From: Stuart Corbey
Sent: 20 December 2018 17:10
To: Planning.Responses
Subject: FW: 2 Pagham Road, P/99/18/HH

Our Ref: P/99/18/HH

**Town and Country Planning (Pre-commencement Conditions) Regulations 2018 -
Notice regarding intention to impose pre-commencement conditions**

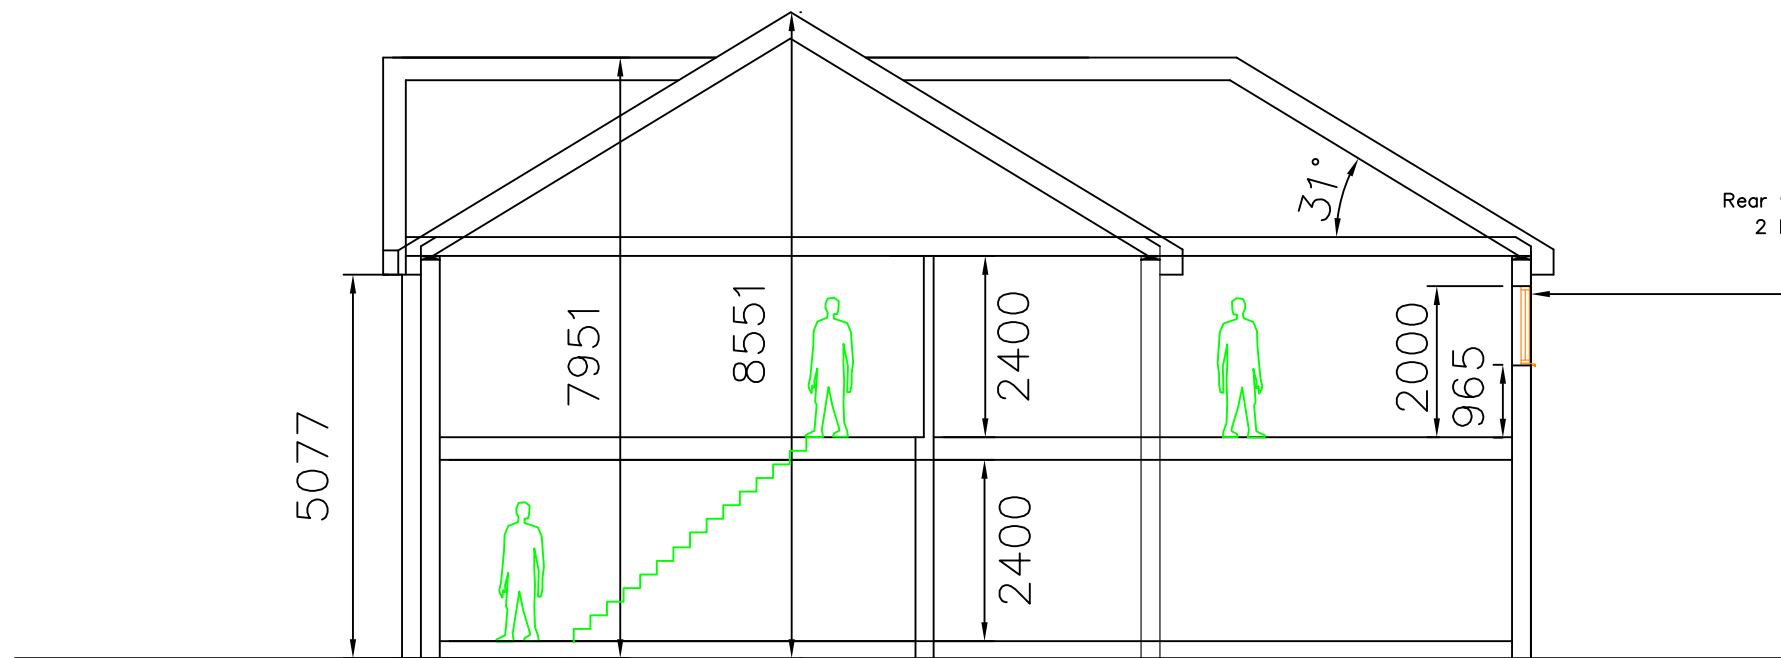
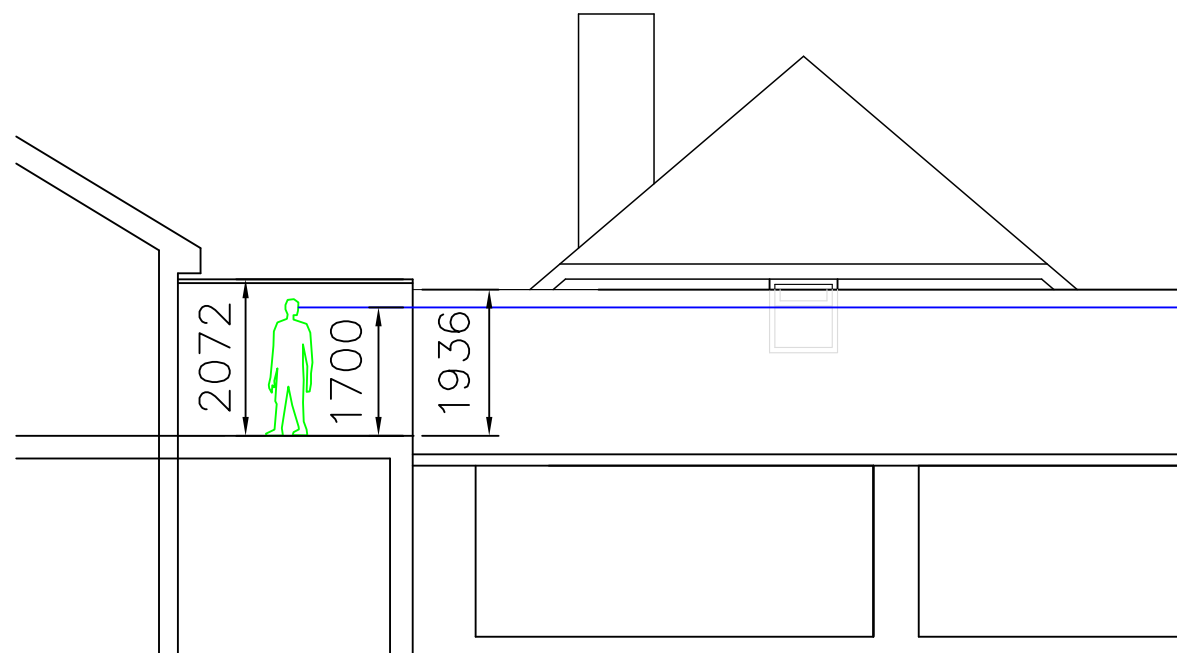
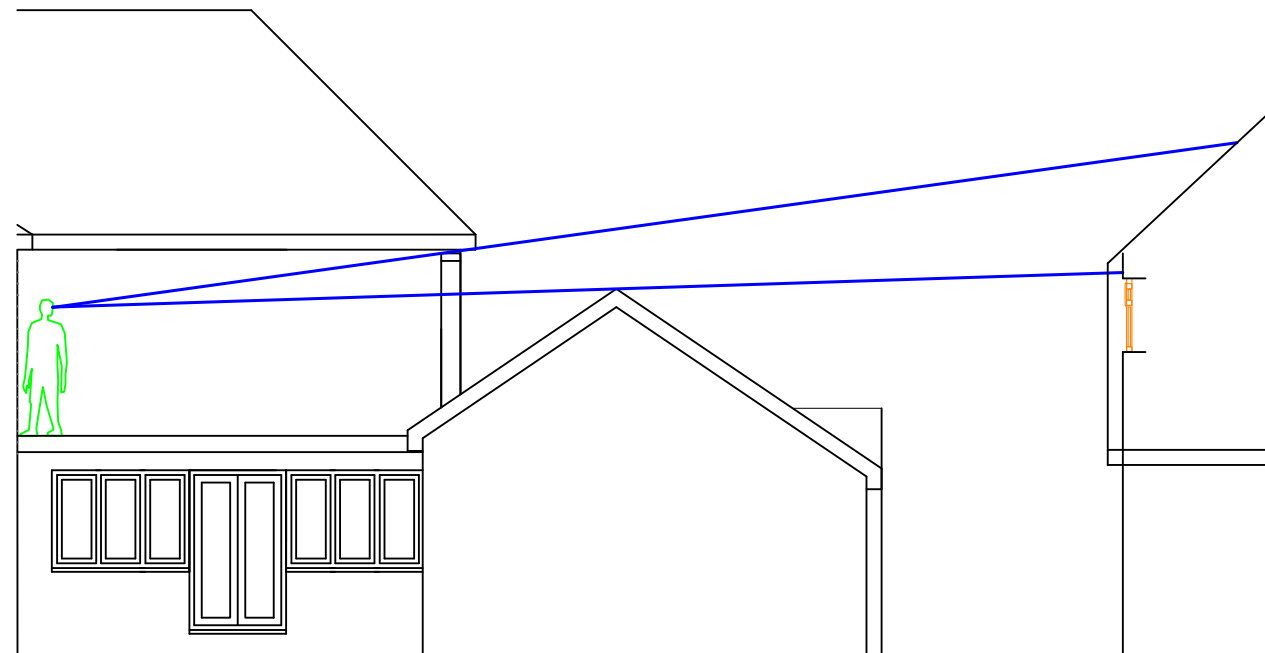
I am not sure what more detail I can provide to the cross-section P006_B so please could you give me a call to explain what exactly you require, and I will get this done immediately. I have left you a voicemail also this morning.

What would be helpful is a cross section and elevation of the proposed development inclusive of the site arrangement with the existing outbuilding (dotted line) in addition to extant permission under P/18/03. This level of plan would make the situation more clear and assist with the assessment.

As per our phone conversation earlier today, please find attached revised drawings to show the existing structures. I have also provided an additional section view to demonstrate the complete obscuration of the side flank window of No. 4 Pagham Road from the balcony area.
